Engineers Comments Regarding Surface Water Drainage

Application Reference:	M/29/26/HH	Reviewer Reference:	ADC/KW/PC
Planning Officer:	Rhiannon Lloyd	Date of Review:	22/06/2026
Site Name:	16 Sea Way, Middleton-on-sea		
Application Description:	Garage to front of property.		
Assessment Number:	1 of 1

Surface Water Drainage Strategy AEG6376_PO22_Middletononsea_05

Proposed Car Port Planning
Date January 2026
Scale 1:200 1:1250

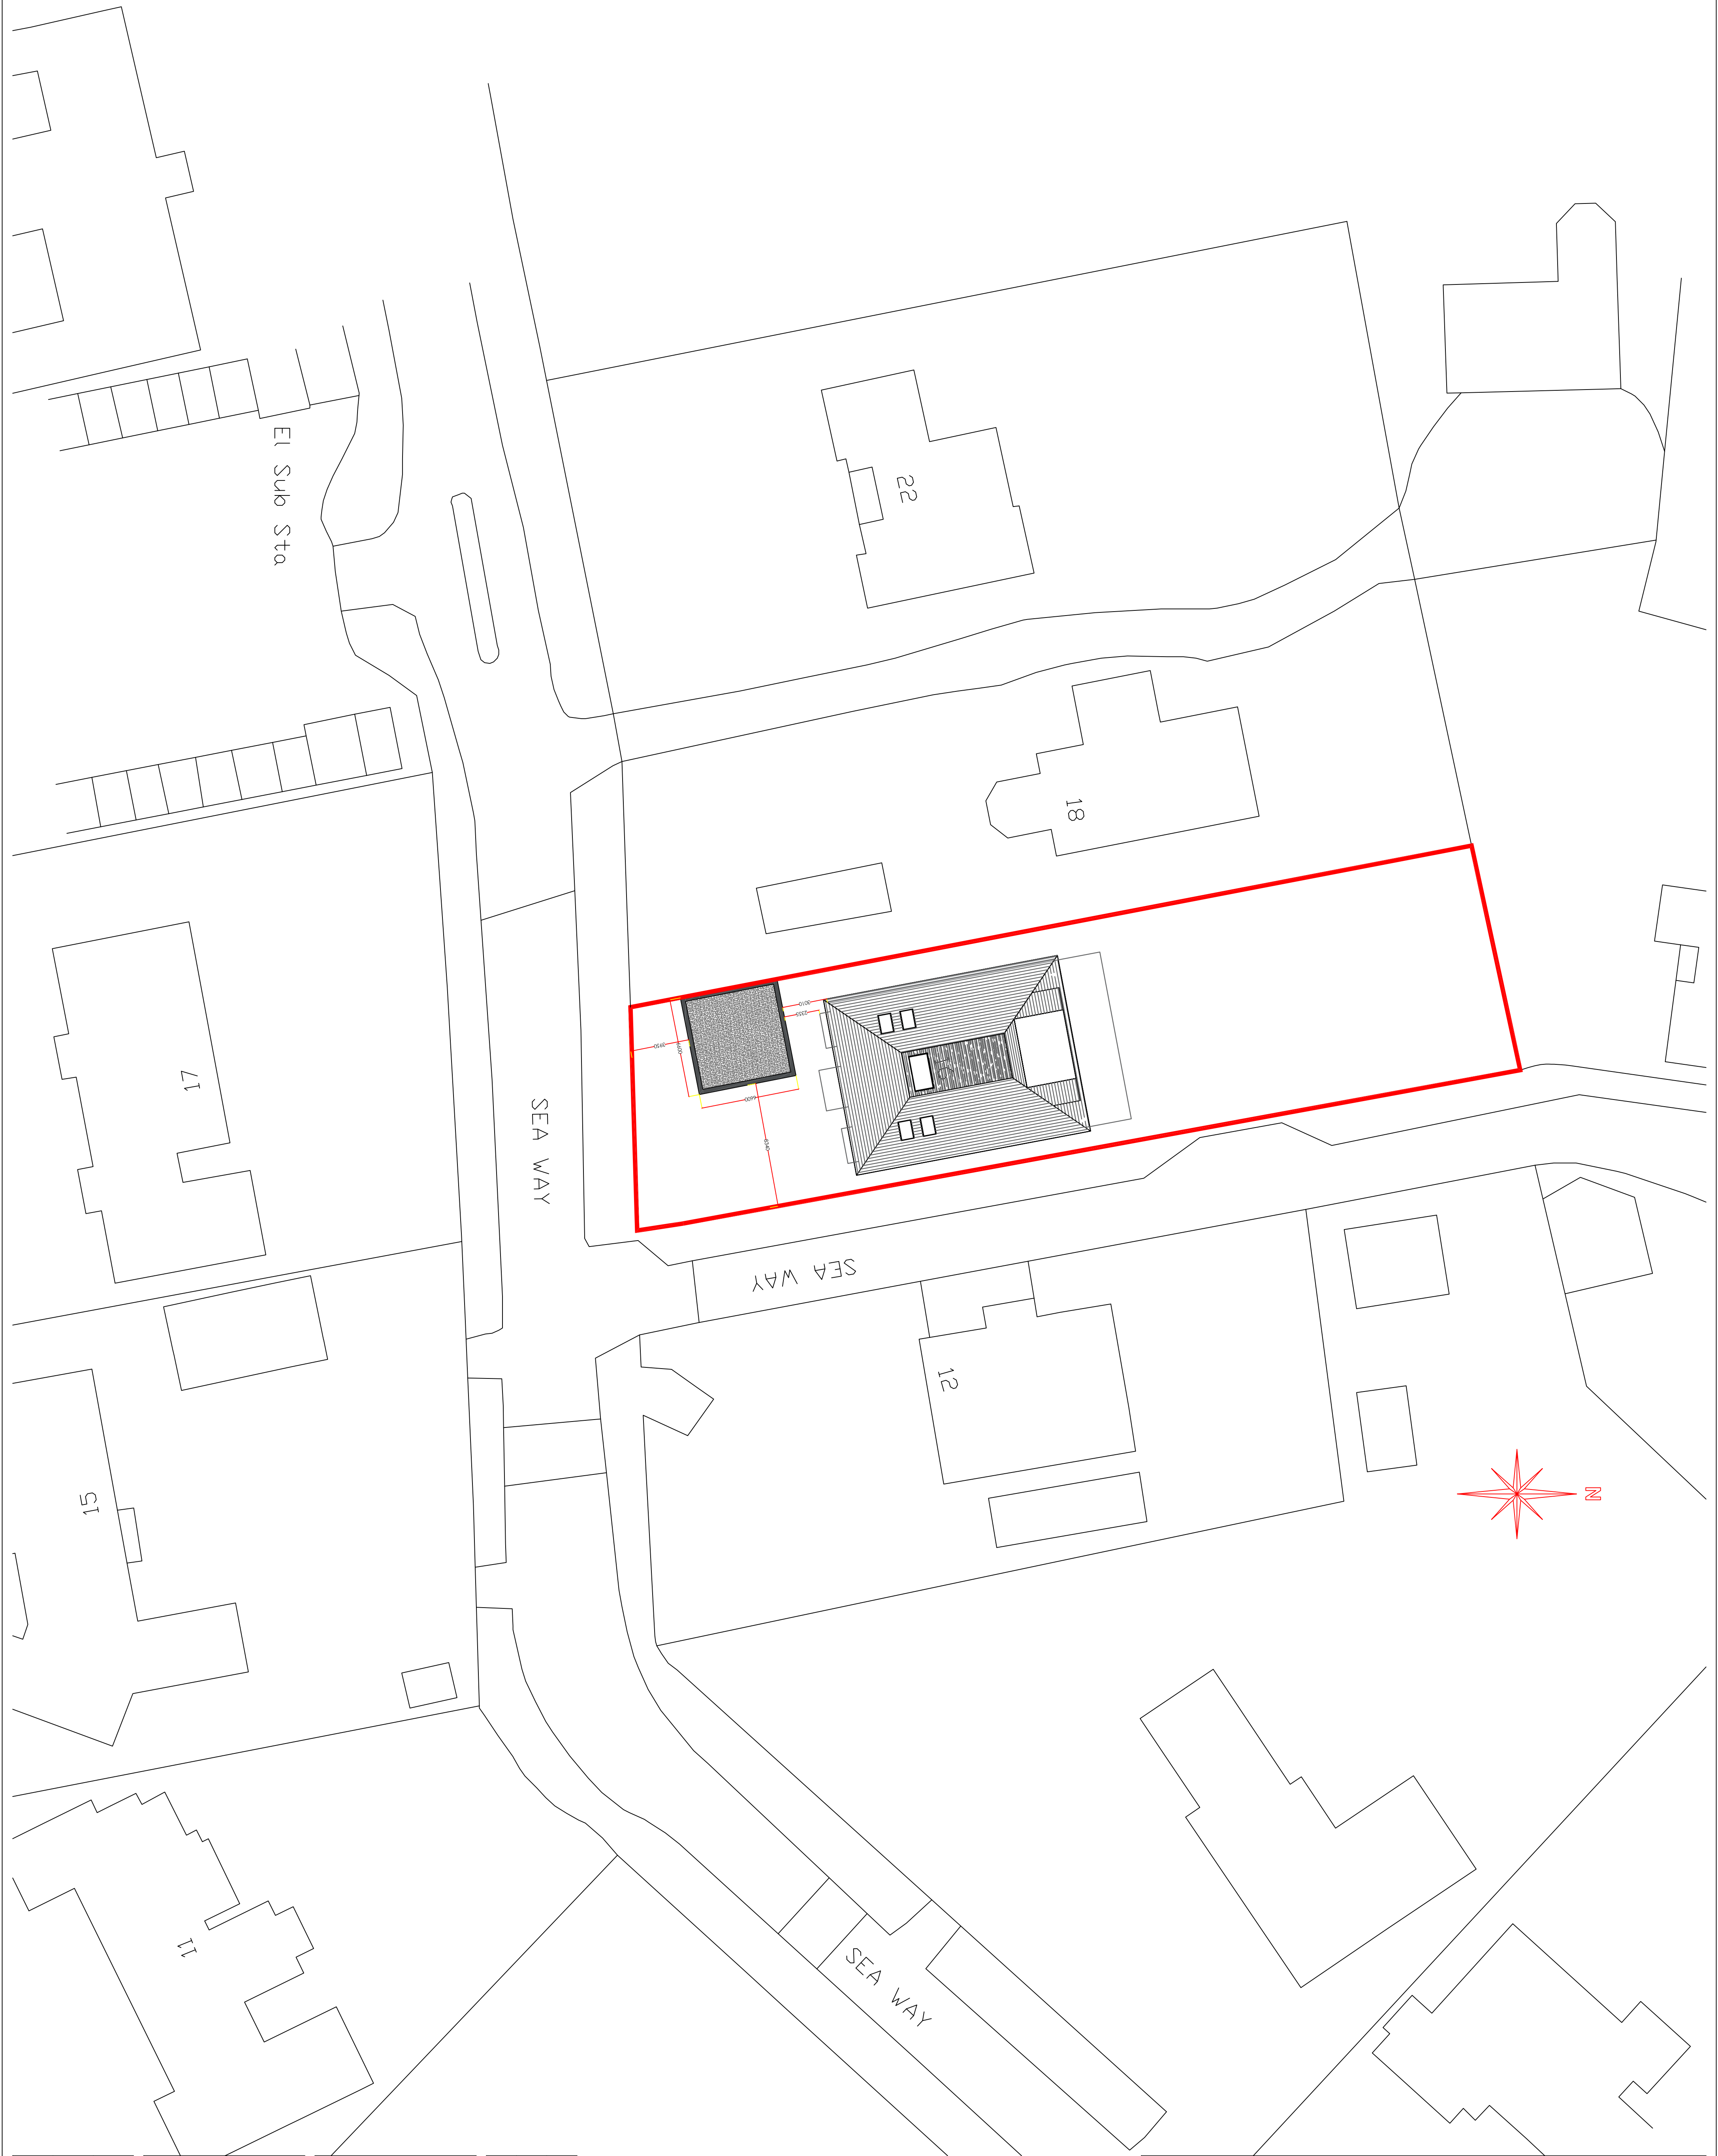
3.3. Furthermore, an area at the front of the proposed dwelling is shown to fall within the future 0.1% Annual Exceedance Probability (AEP) surface water flood extent. This area appears to interact with the footprint of the proposed garage and, as such, further assessment is required to demonstrate the implications of future flood risk for the proposed development.

3.4. These events (3.3) may need to be accounted for in any design. For further guidance, please refer to our *SuDS in Flood Areas* document available online at www.arun.gov.uk/surfacewater.
